AA/SM/MR
17101
8 September 2017

**SECTION 96(1A) MODIFICATION APPLICATION - SSD 6513
BUILDING R1, BARANGAROO SOUTH**

On behalf of Lendlease (Millers Point) Pty Ltd, we hereby submit an application pursuant to Section 96(1A) of the *Environmental Planning and Assessment Act 1979* ('EP&A Act') to modify State Significant Development Application ('SSDA') SSD 6513 relating to Building R1, Barangaroo South ('the site').

The modification (Modification 3) seeks changes to the ground floor outdoor dining area in response to design development and liquor licensing requirements, and the introduction of integrated signage zones within the revised ground floor design. These amendments do not impact on the built form, scale or aesthetics of the development and will not affect access from the public domain. The development, as proposed to be modified, will remain substantially the same as approved.

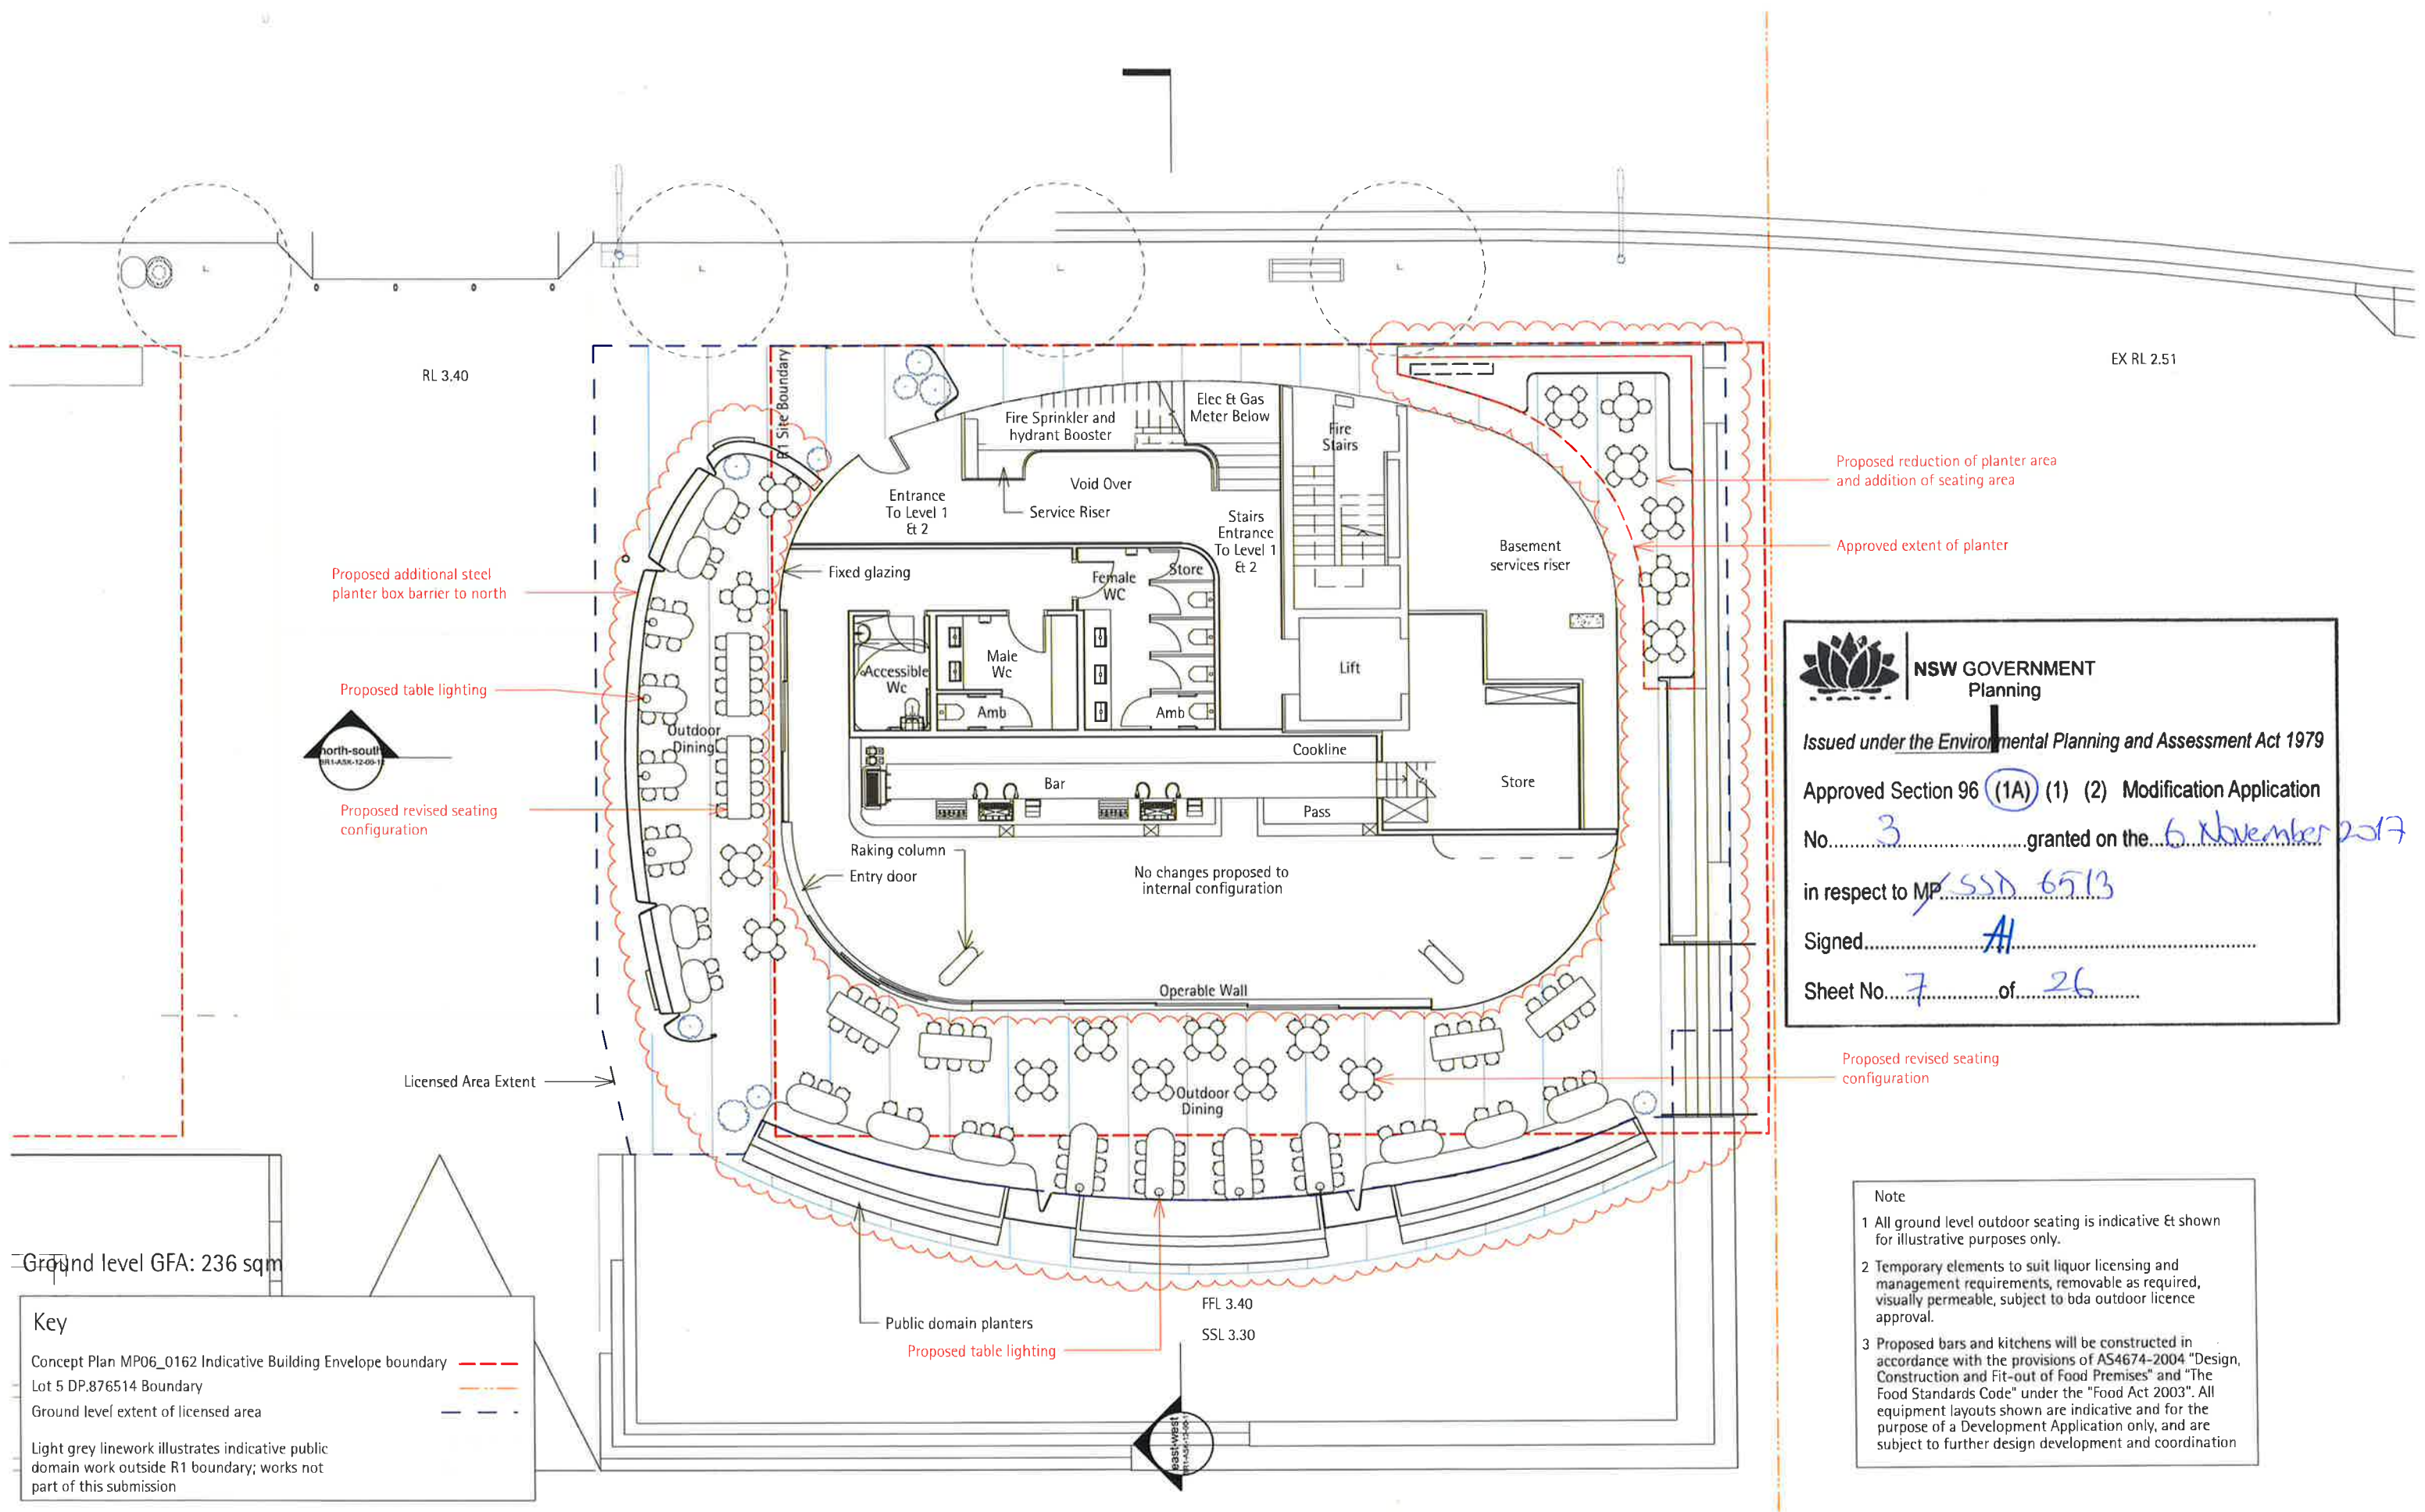
As detailed in the Architectural Plans prepared by Collins and Turner and provided at **Attachment A**, this modification proposes changes to the ground floor outdoor dining area of Building R1 and includes the following:

The approved planter boxes are proposed to be refined to demarcate the ground floor outdoor dining area of Building R1, from the adjoining public domain. This will clearly delineate the licensed premises and extent of the licenced area, in accordance with liquor licensing and management requirements, and reduce overflow into the public domain.

The amended planter boxes will be folded metal and will include:

- A planter box with a height of 900mm to be positioned to delineate the northern licensed outdoor dining area;
- A planter box with a height of 900mm to be positioned to delineate the south eastern licensed outdoor dining area; and
- The introduction of planter boxes to fill the space between approved planter boxes on the western façade.

A total of six (6) signage zones are proposed to be integrated within the refined ground level design and layout. The zones will be positioned above entry doors and against the proposed ground floor steel planter boxes surrounding the building. Specifically:

- A signage zone with dimensions of 1200mm x 600mm is proposed over the entry door on the north-east corner of building façade;

- A signage zone with dimensions of 2000mm x 600mm is proposed on the exterior of the steel planter box on the northern façade adjacent to the entry door;
- A signage zone with dimensions of 2000mm x 600mm is proposed on the exterior of the steel planter box on the southern façade; and
- A signage zone with dimensions of 2000mm x 600mm is proposed on the exterior of the steel planter box on the western façade.

- Alteration of ground floor handrails to match existing public domain handrails;
- Change of operable to fixed window glazing for the northern façade;
- The relocation of the water metre to the eastern garden bed;
- Revised external table lighting and seating configuration; and
- Redistribution of external ground floor seating, including provision of an additional zone on the south eastern corner of the building.
